Re : Land off Wilson Ave, Penistone, Barnsley. Ref: 2012/0023.

I refer to your recent communication regarding the above development and I enclose three copies of amended drawings with the following changes:

SITE PLAN 1:200

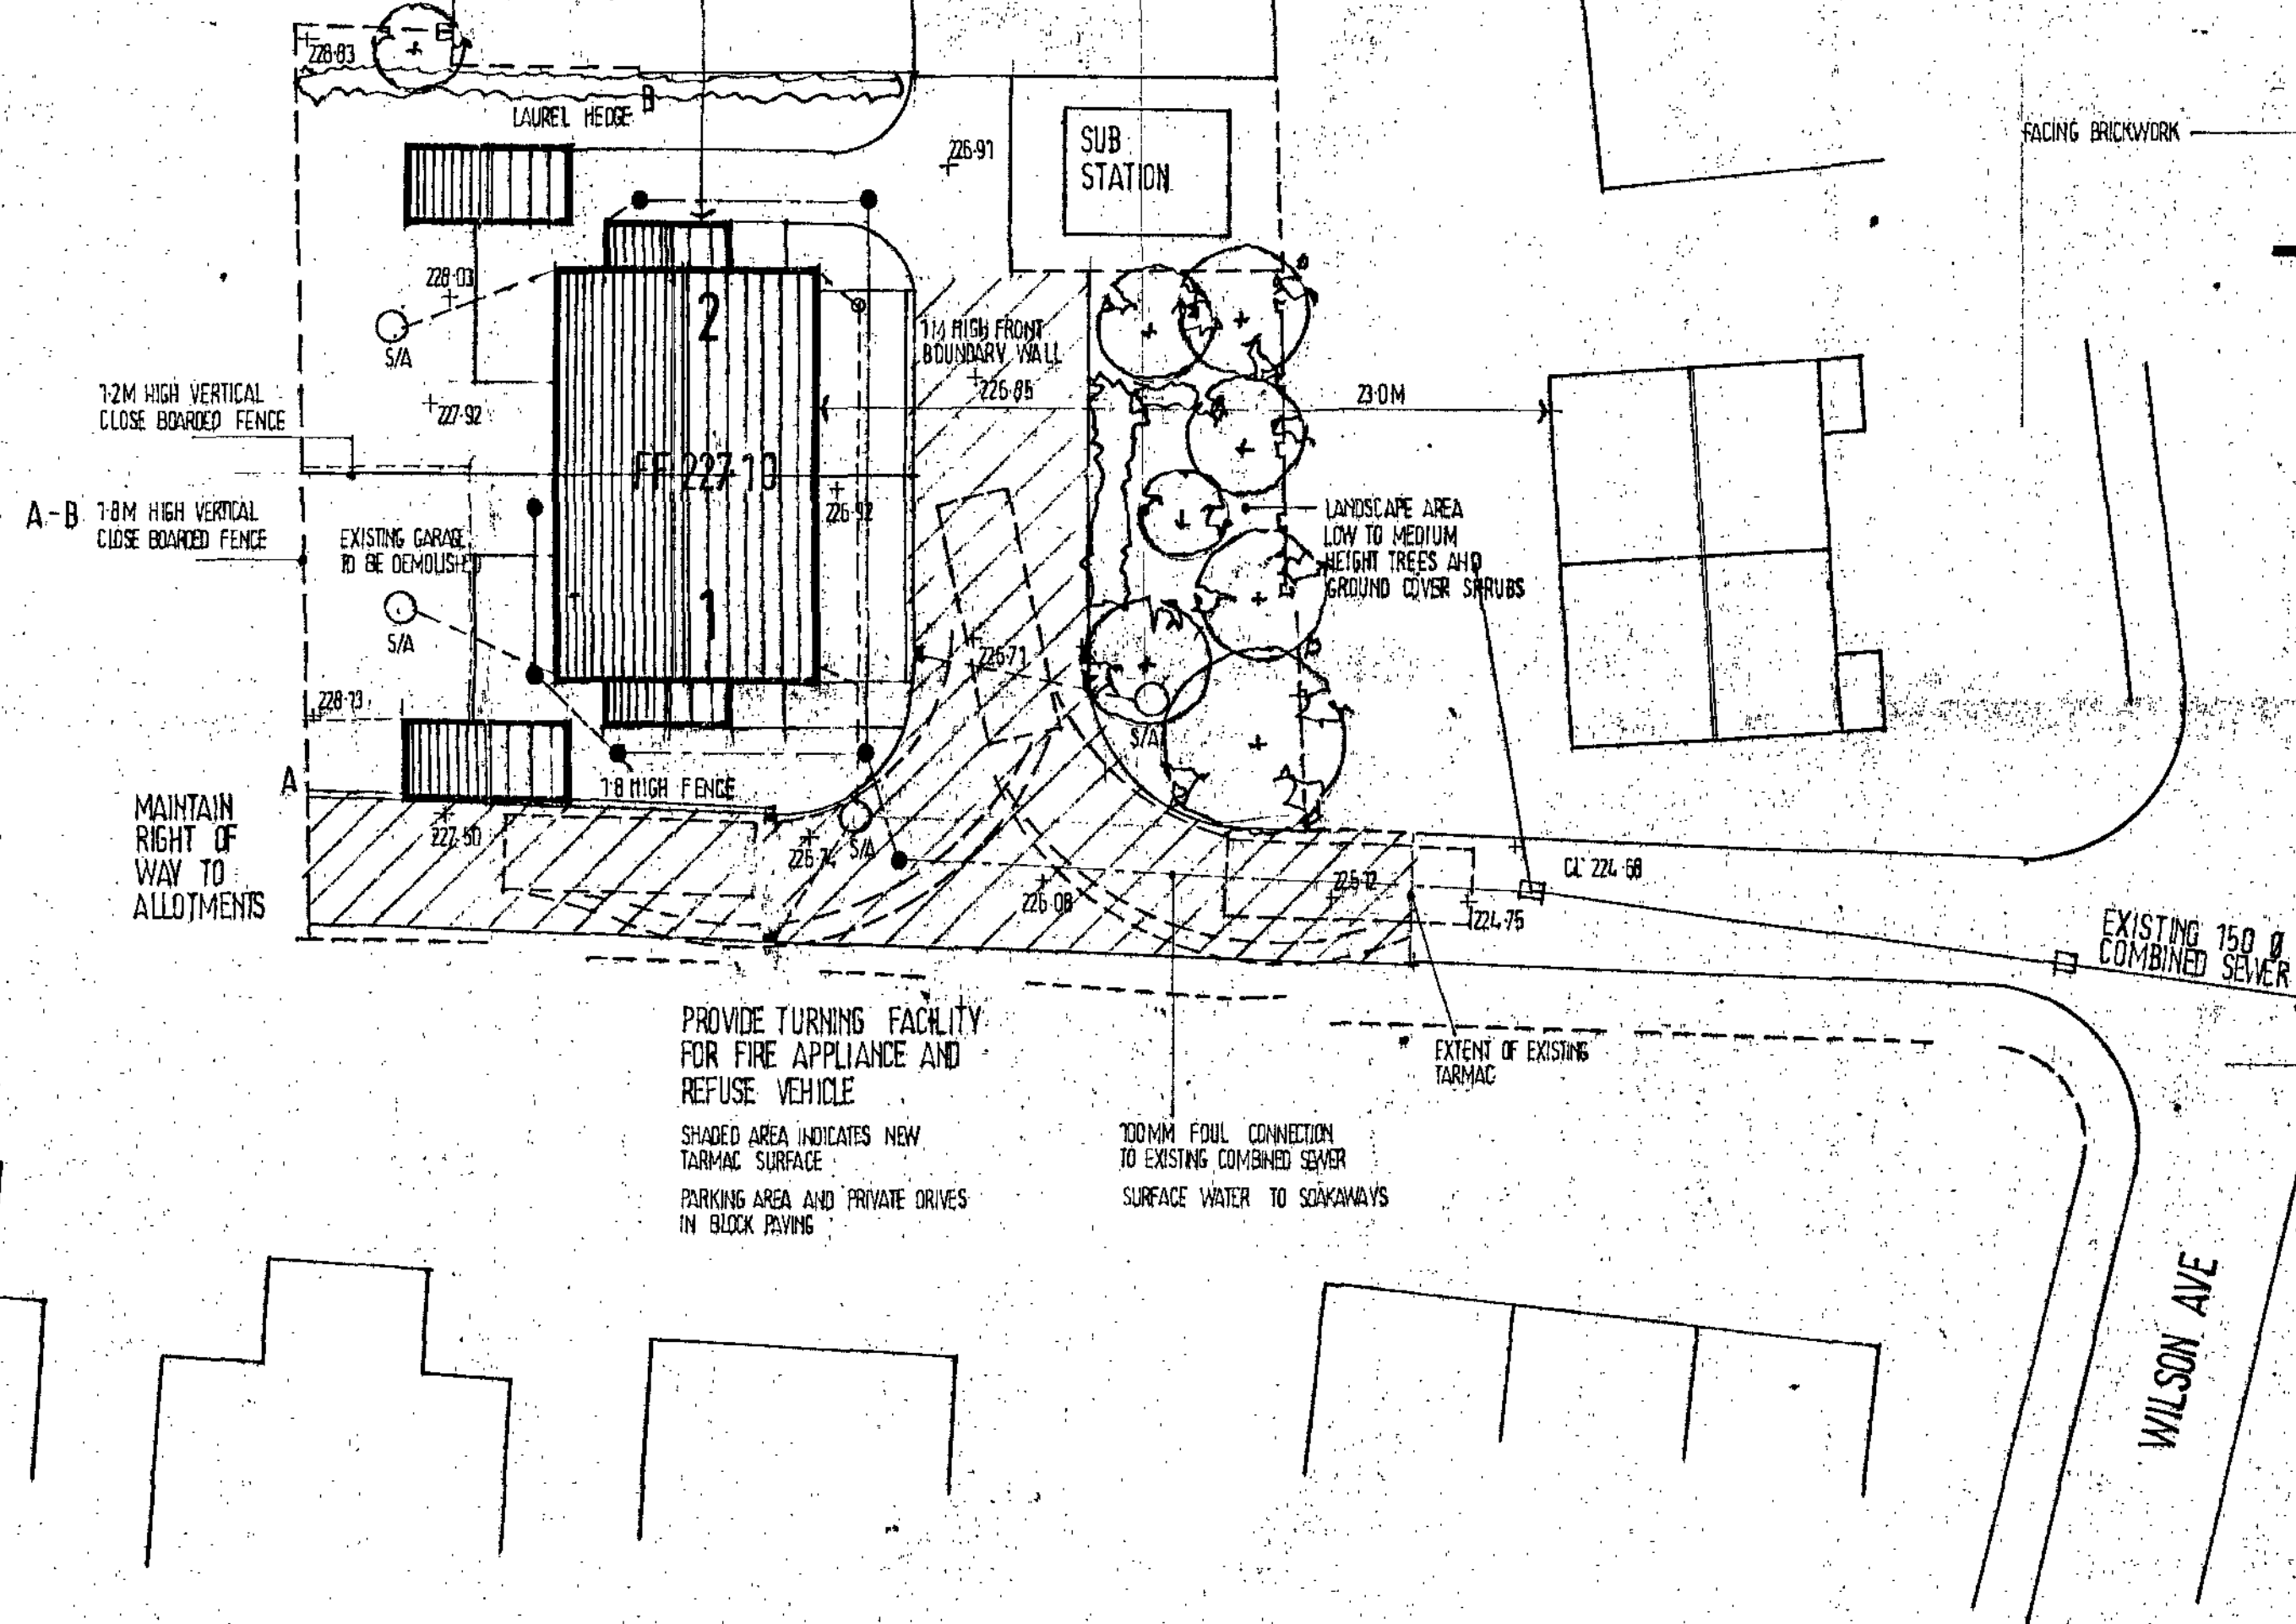
- The parking area to the rear of 7 and 9 Wilson Ave has been omitted and the area landscaped.
- The boundary treatment in front of the dwellings will be a 1m high wall.
- A 1.8m high fence will be erected between the track to the allotments and the rear gardens.
- The front elevation has been amended, whilst I agree that a red facing brick is acceptable, I would prefer to keep the ashlar stone panel.
- The rear gardens have been marked on the plans.
- Regarding the northern boundary to Victoria Street I feel there is insufficient space for a landscaping strip but would agree to a Laurel hedge as shown.
